From:
To: [DCAdmin](#)
Cc: [Nick Hirst](#)
Subject: Planning Application 2020/93954 - CRPD
Date: 19 January 2023 14:19:40
Attachments: [CRPD.pdf](#)

Please find attached a personal comment concerning the revised housing development off Lingards Road.

House Type A1.

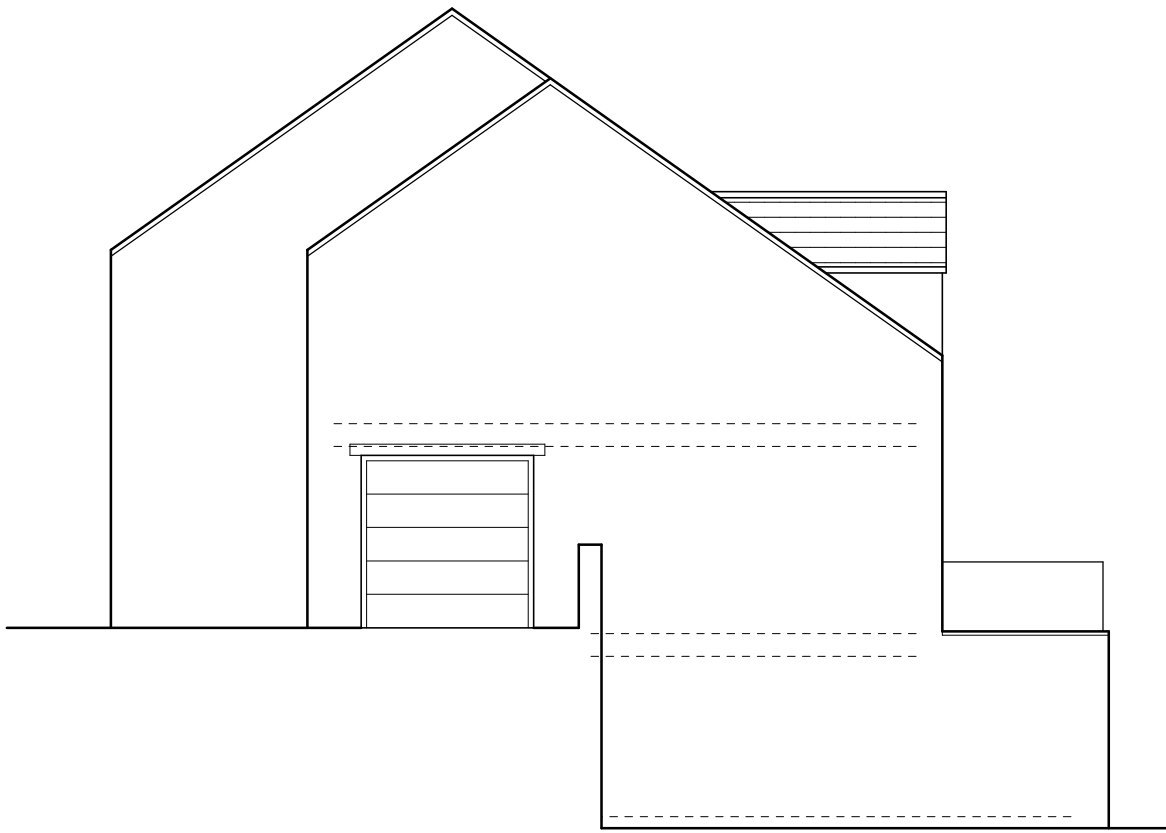
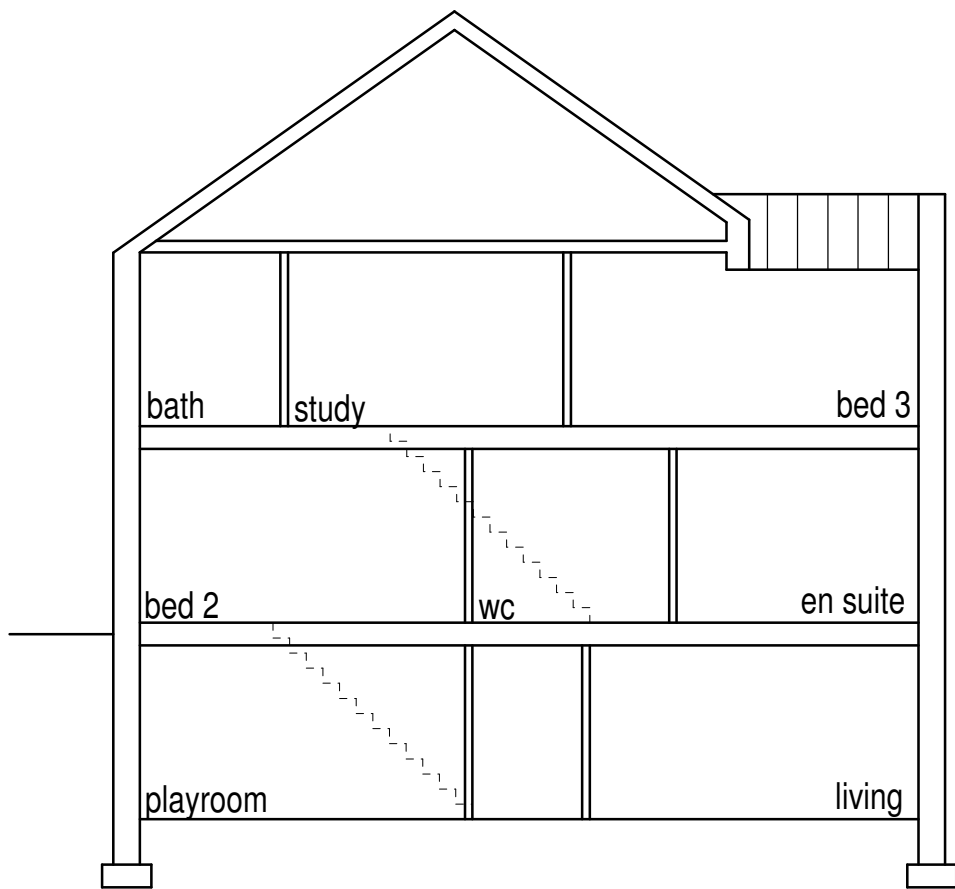
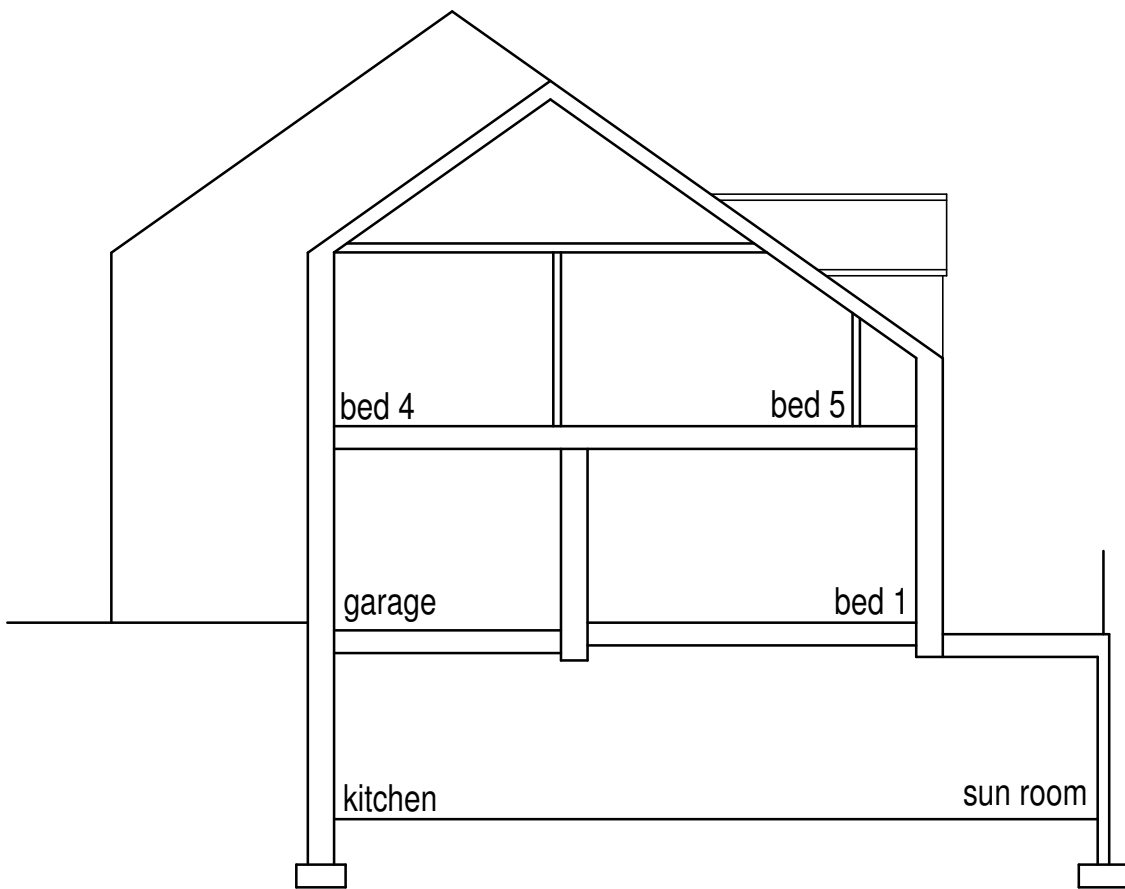
House type A1, like other proposed dwellings in this application, is planned to be built with a 14.8cm lintel, which effectively presents as a step: *see image right*.

In my view, it would represent a worthy contribution towards removing barriers to wheelchair users.

This is why 14.8cm steps are permitted.
